CITY OF ALBUQUERQUE

RE: **Garcia Honda Gen 3 Service Bldg**
8301 Lomas NE
Grading and Drainage Plan
Engineer's Stamp Date 8/14/17 (File: J19D072)

Based on the information provided in your submittal received 8/17/17, the Grading and Drainage Plan cannot be approved for Building Permit until the following are addressed:

Mark	Date	Description
	05/05/17	
	15918	
	JUB	
Drawn By		
Checked By		
Copyright ©		VAN H. GILBERT ARCHITECT
PC		
SHEET TITLE		
GRADING, DRAINAGE & UTILITY SERVICE PLAN		
C-101		
SHEET

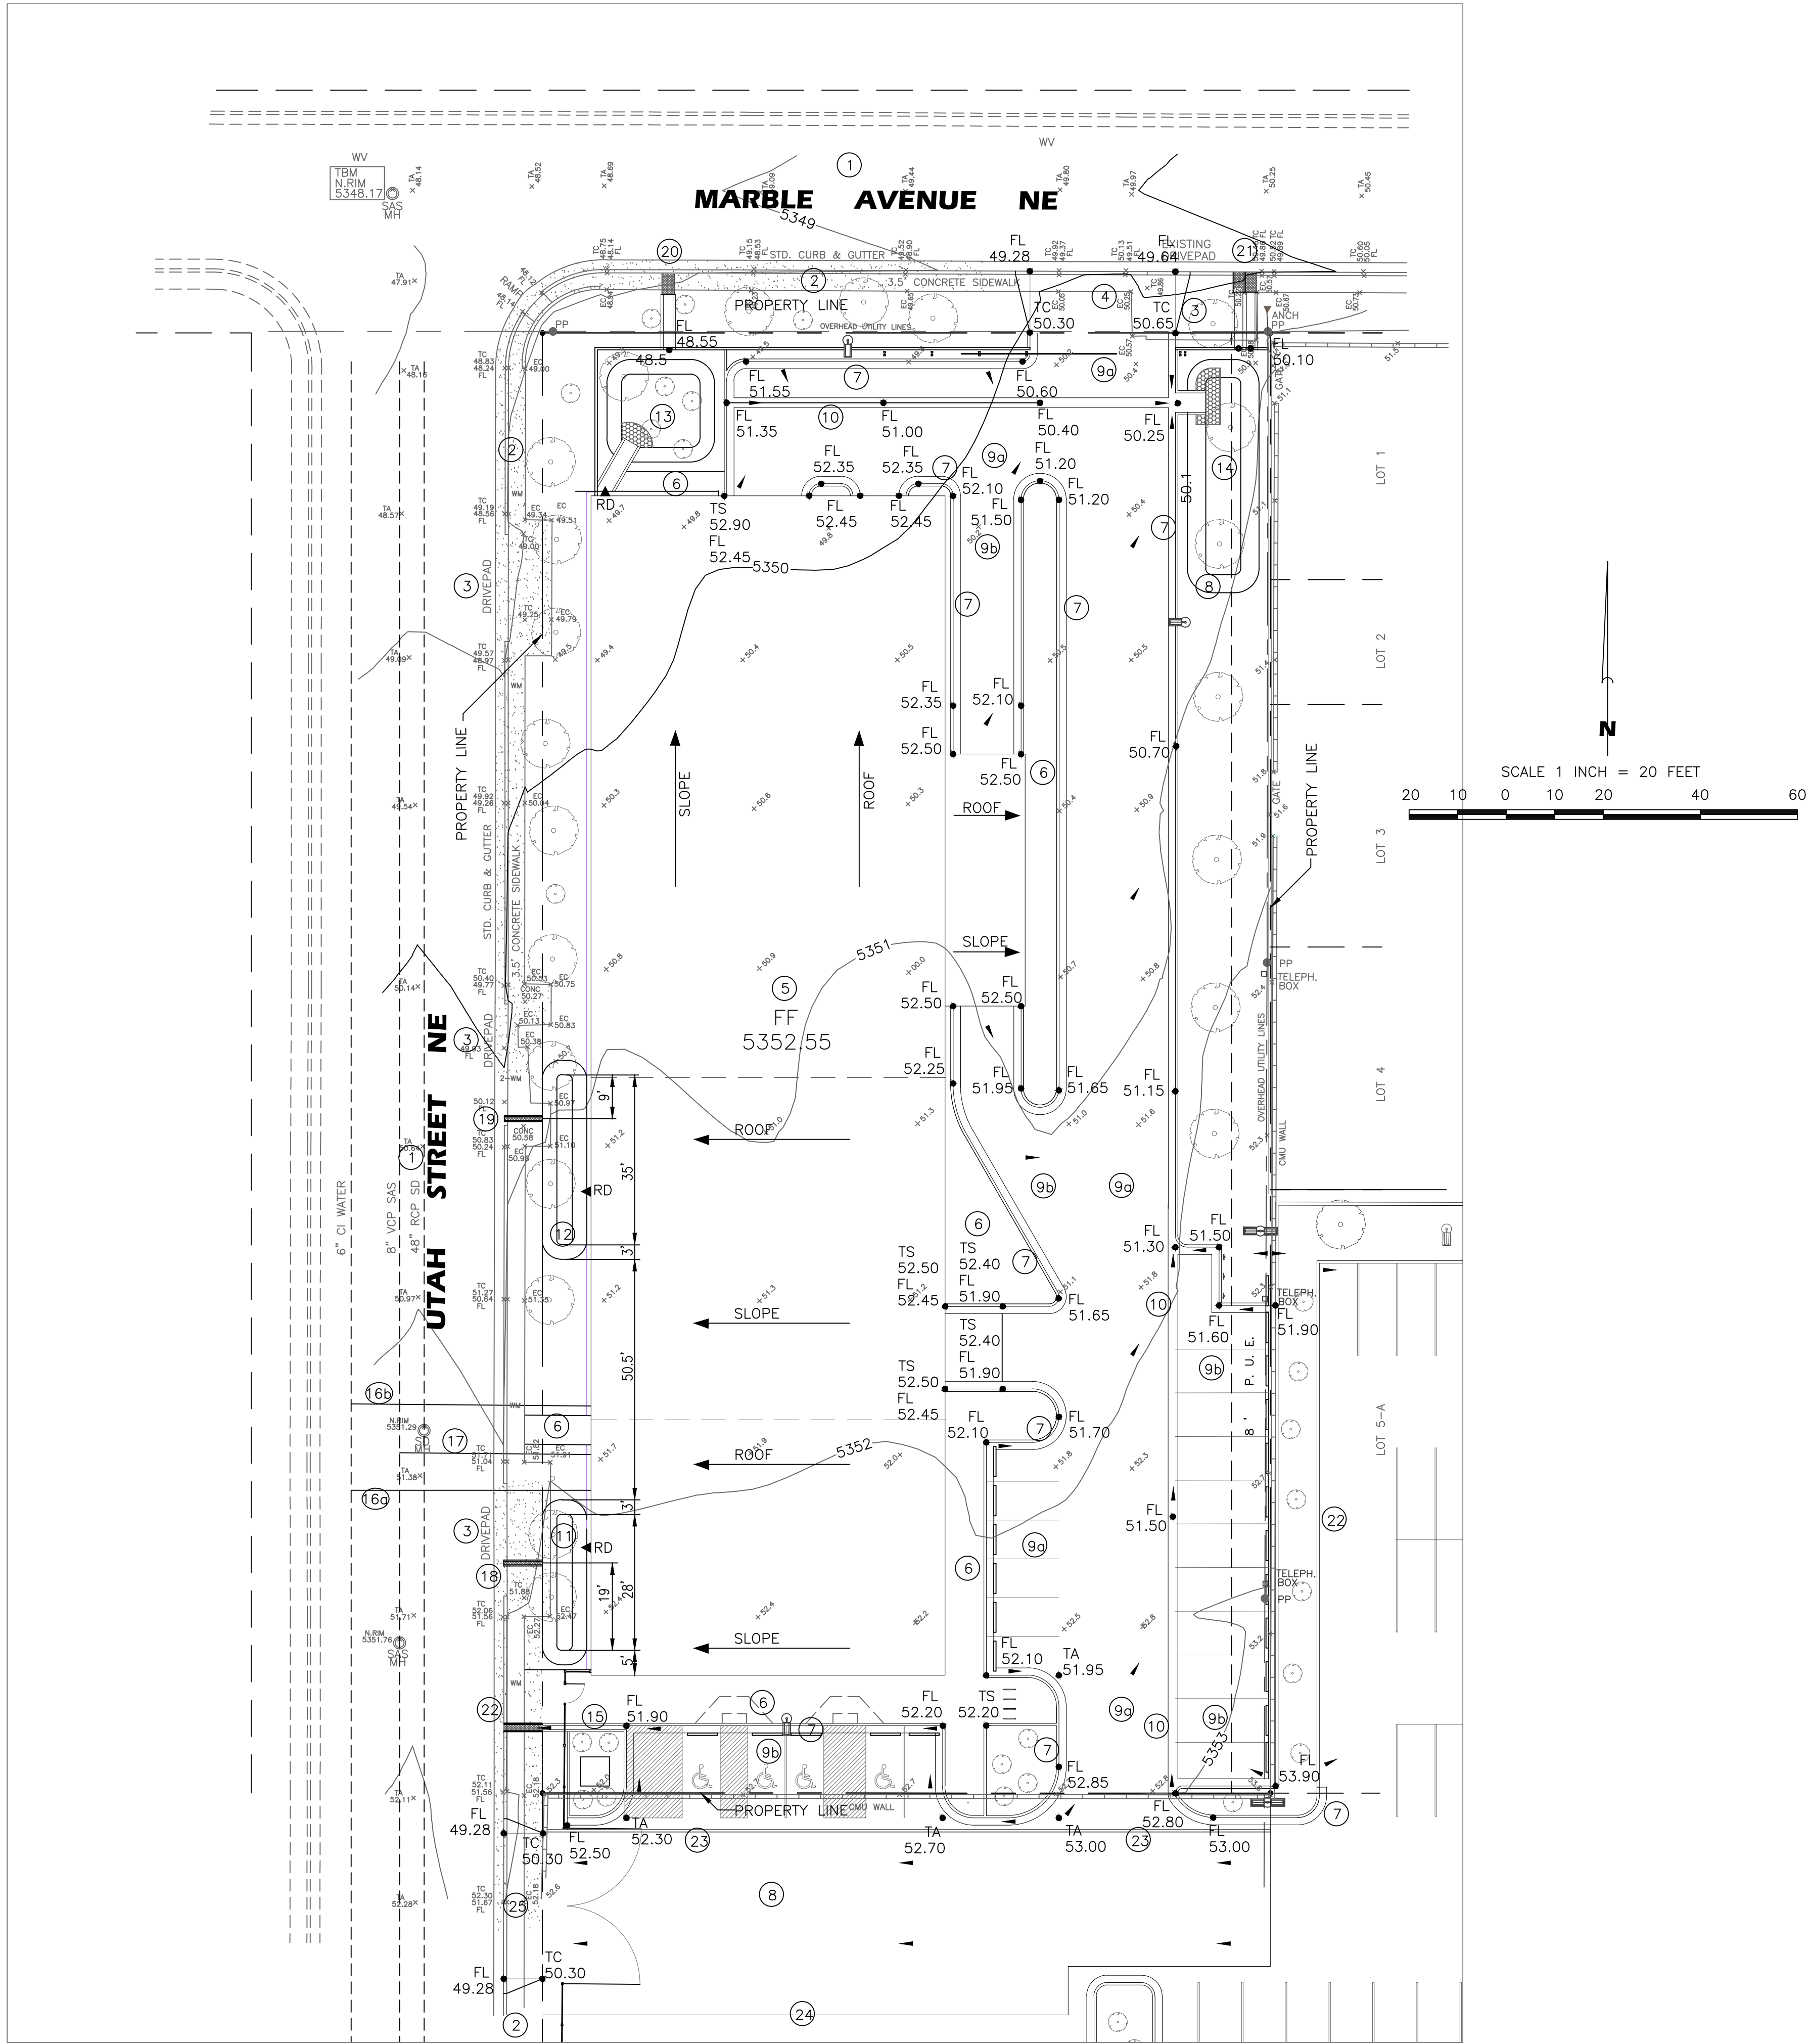
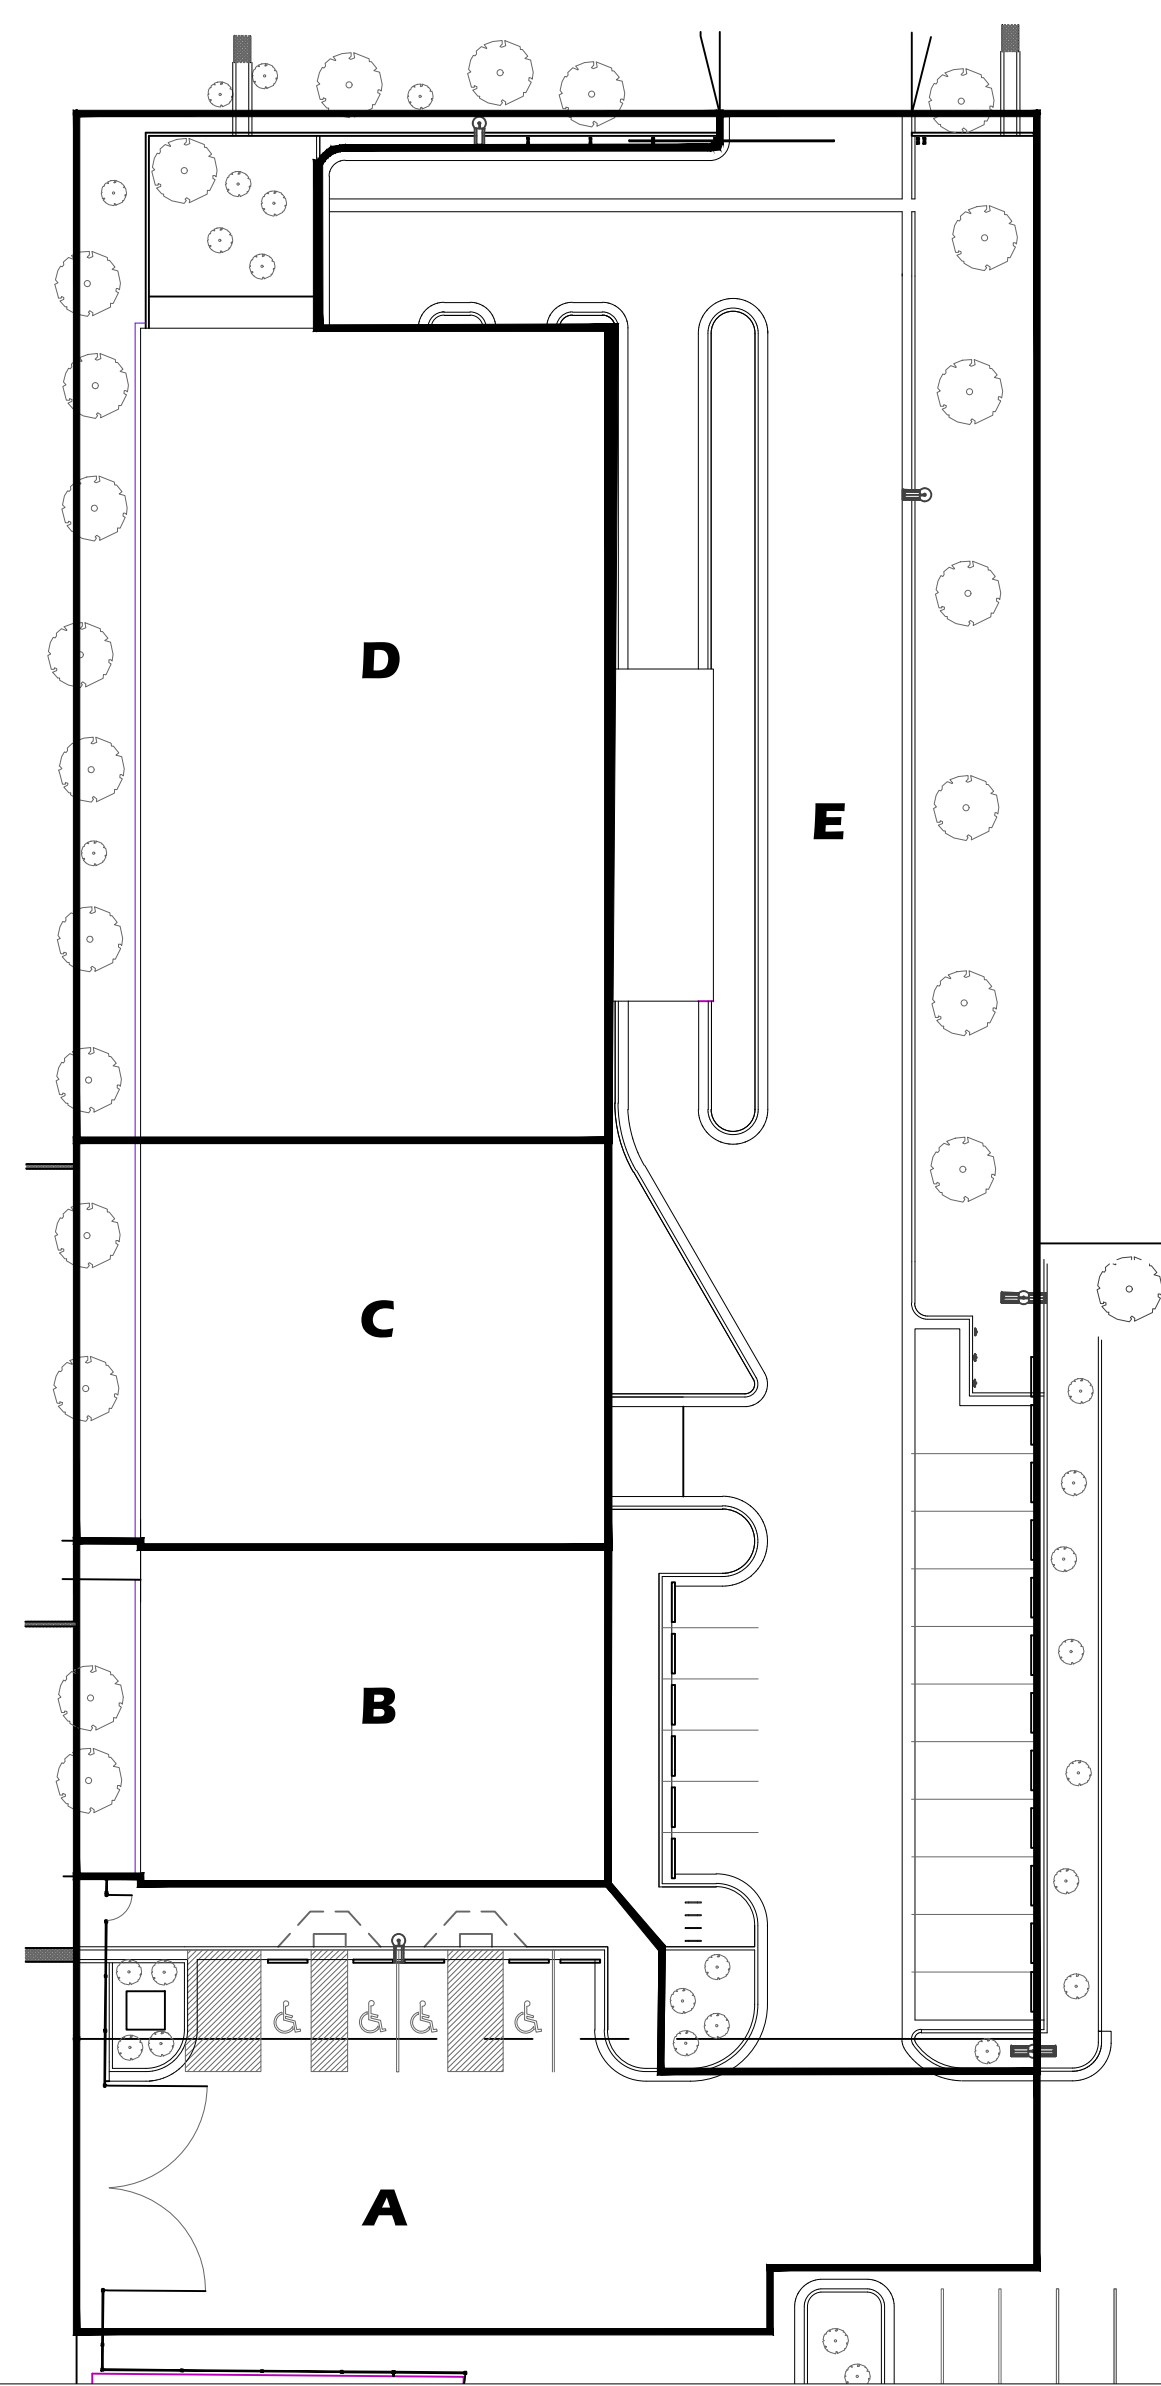
1. Show the pond limits and add bottom of pond elevations.
2. A recorded Private Facility Drainage Covenant is required for the ponds (outline attached). Please contact Charlotte LaBadie (clabadie@cabq.gov, 924-3996) or Madeline Carruthers (mtafoya@cabq.gov, 924-3997) regarding the routing and recording process for covenants.
3. This work requires an Erosion and Sediment Control Plan to be submitted to the storm water quality engineer (Curtis Cherne, PE, ccherne@cabq.gov).
